**re:    Geotechnical Response to Peer Review Comments**  
**Proposed Residential Development – Conservancy**  
**Borrisokane Road - Ottawa**

**date:   June 3, 2021**

**file:   PG5036-MEMO.01 Rev. 1**

Figure 12 - Test Fill Pile Settlement Monitoring Program  
Caivan - Conservancy Lands East - Borrisokane Road - Ottawa

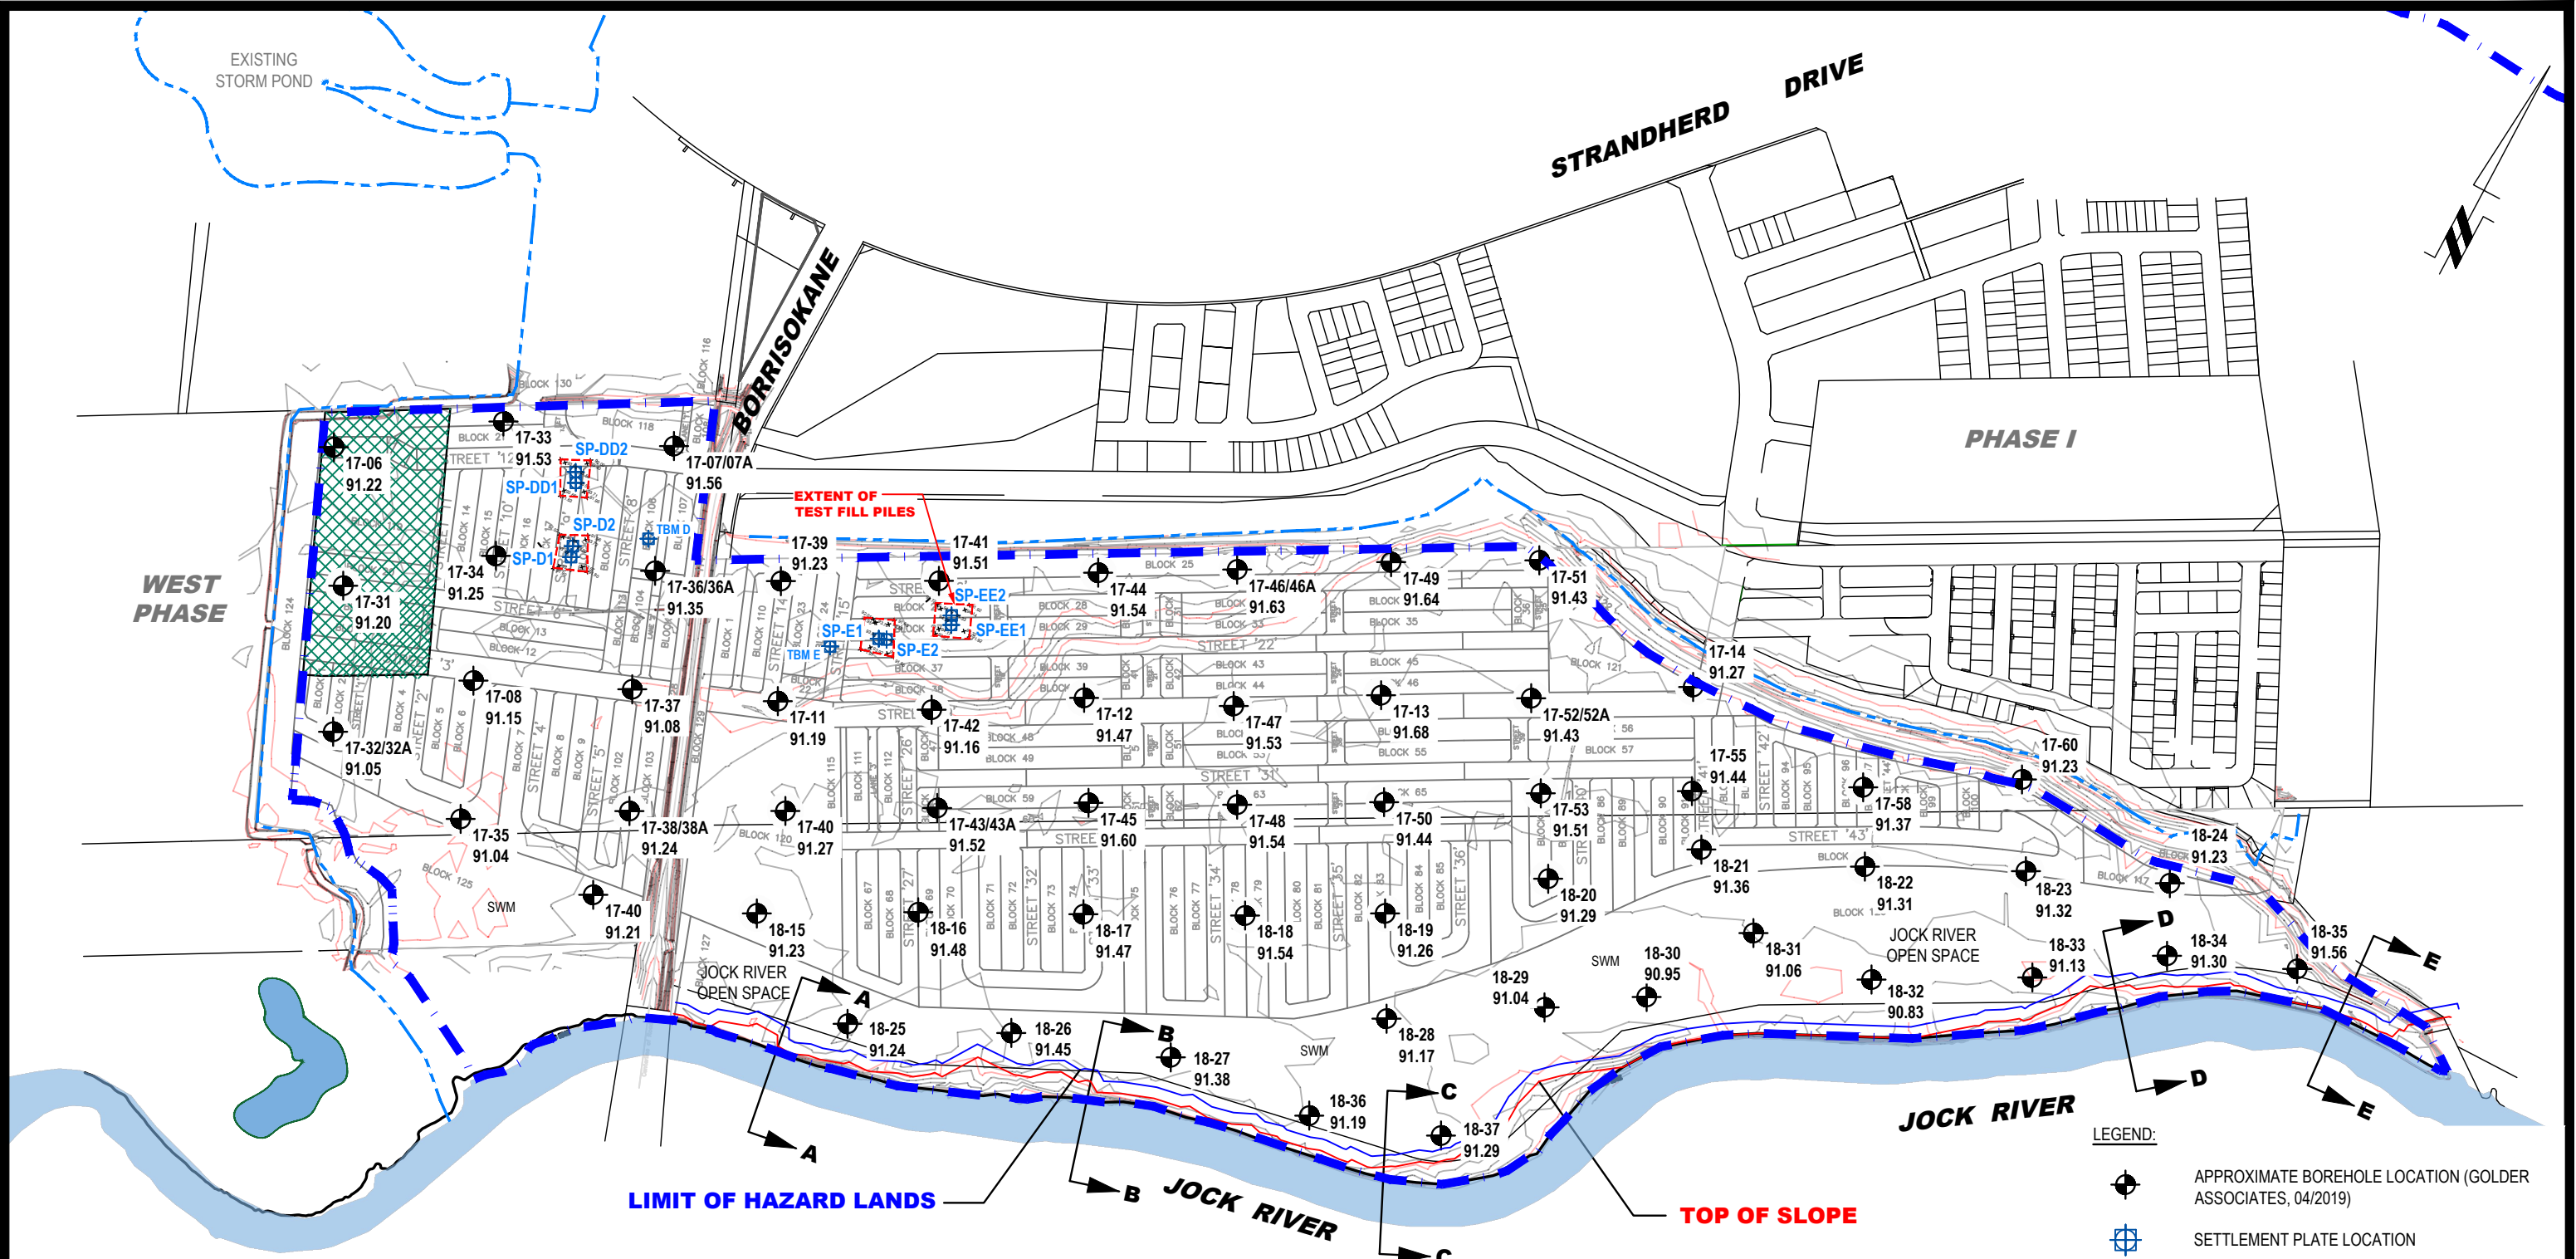
To elaborate on our process, we have used the similarities of the area clay deposits and the results of the settlement test fill program that is underway for the subject site to confirm our permissible grade raise recommendations for the site. The latest results of the settlement test fill program are presented in Figure 2 attached. Test fill piles, Pile E and EE, are located in the area of the highest roadway grade raise for the site. The test fill pile locations (Piles E and EE) and top of test fill pile elevations are presented in Figure 1 on the following page.

The settlement monitoring results for Piles E and EE to date are indicative of acceptable settlement levels for roadways and associated service pipes for proposed grade raises of up to **2.3 m (el. 93.3 m)** without excessive settlement. Based on the testing results, the majority of the settlement associated with the grade raise occurs within the first 3 to 4 months after fill placement and it should be noted that the placement of service pipes will occur well beyond that timeline. The highest finished roadway grades are also 0.6 m to 1.0 m below the top of the top of Piles E and EE, respectively. Therefore, the service pipe alignments are expected to have to tolerate a minor amount of settlement ranging between 15 to 20 mm. This amount of settlement is tolerable for conventional water, sanitary and storm pipe materials and conventional connections for manholes and catch basins.

Scale:	1:6000	Date:	09/2019
Drawn by:	MPG	Report No.:	PG5036-1
Checked by:	OC	PG5036-2	Revision No.: 2
Approved by:	DJG

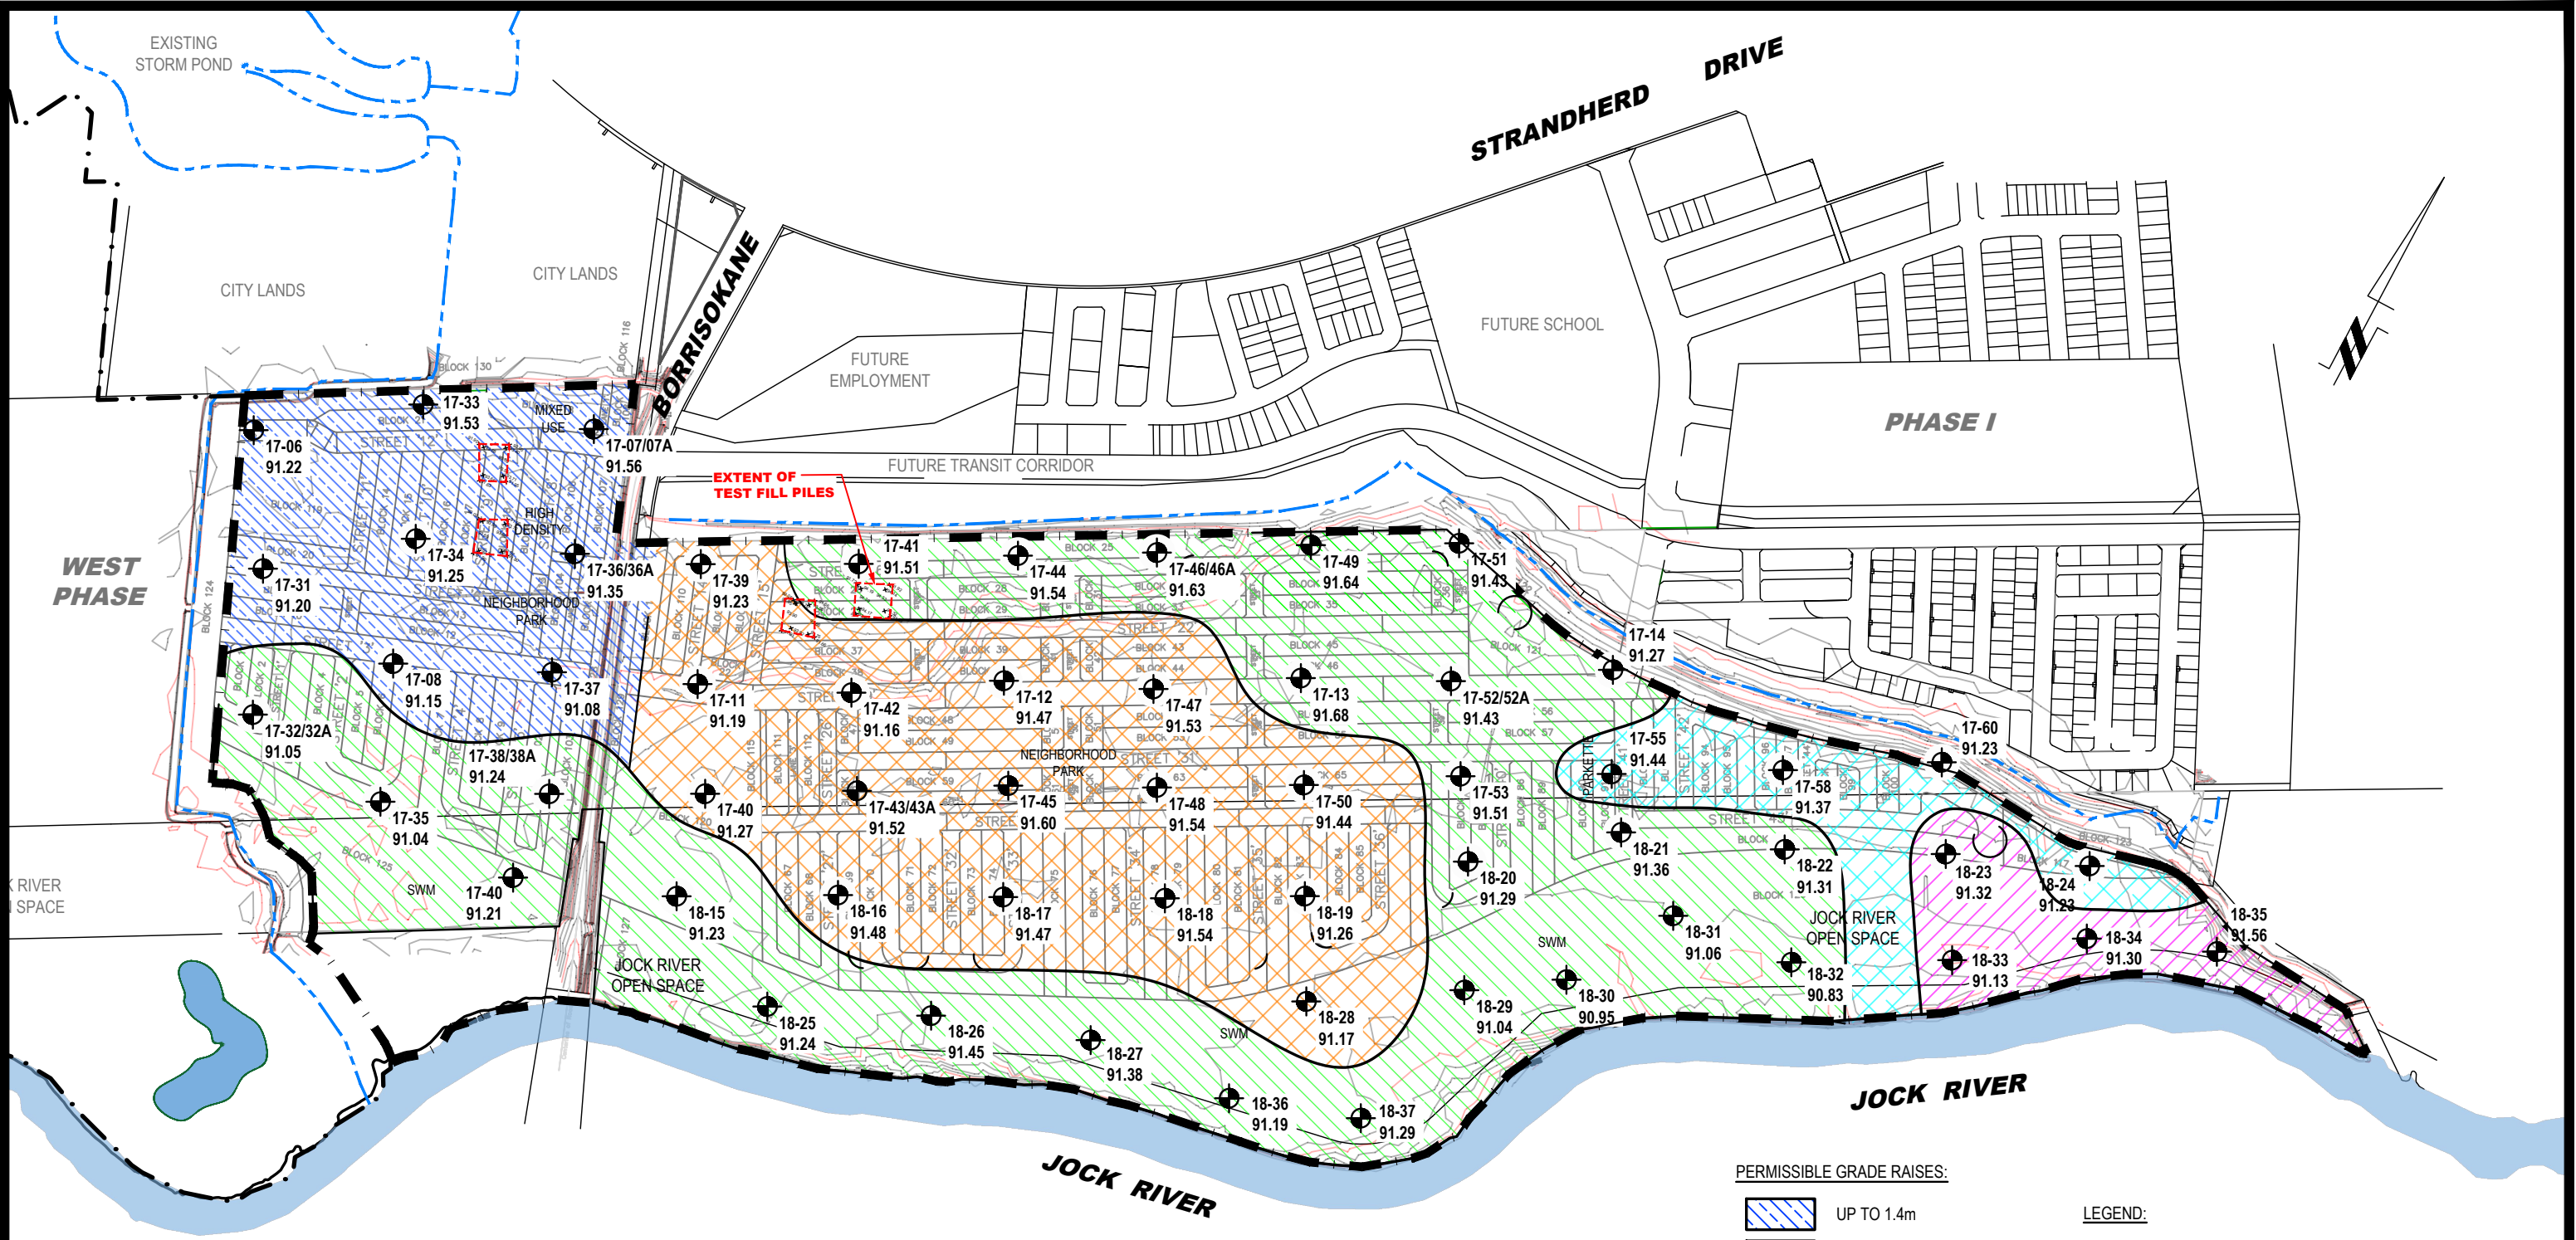
As noted in Paterson Report PG5036-1 Revision 2 dated May 25, 2021, our permissible grade raise recommendations are based on the consolidation testing results, test fill settlement monitoring results and undrained shear strength values at the borehole locations and our experience with local Ottawa clays. It should be noted that the undrained shear strength values and clay crust thicknesses noted at the borehole locations across the site are similar to soil profiles encountered by Paterson at adjacent sites in the vicinity of subject site. We have also successfully completed several surcharge and settlement test fill monitoring programs at these same adjacent sites, which have helped us to identify accurate permissible grade raise recommendations for those clay deposits. The successful development of those adjacent sites has further confirmed that our design assumptions used for determining the permissible grade raise recommendations are suitable for residential developments over sensitive silty clay deposits.

The area presented in Figure 1 is representative of the highest grade raises for the subject roadways at the subject site. The required grade raise above original ground surface varies between 1.5 to 2.3 m (max. el. 93.3 m). Therefore, based on our observations of the settlement monitoring program, the underlying soil profile across the site and our knowledge of settlement and clay deposits in the area, Paterson can confirm that the proposed roadway grading is acceptable from a geotechnical perspective and lightweight fill will not be required for the subject roadway alignments.
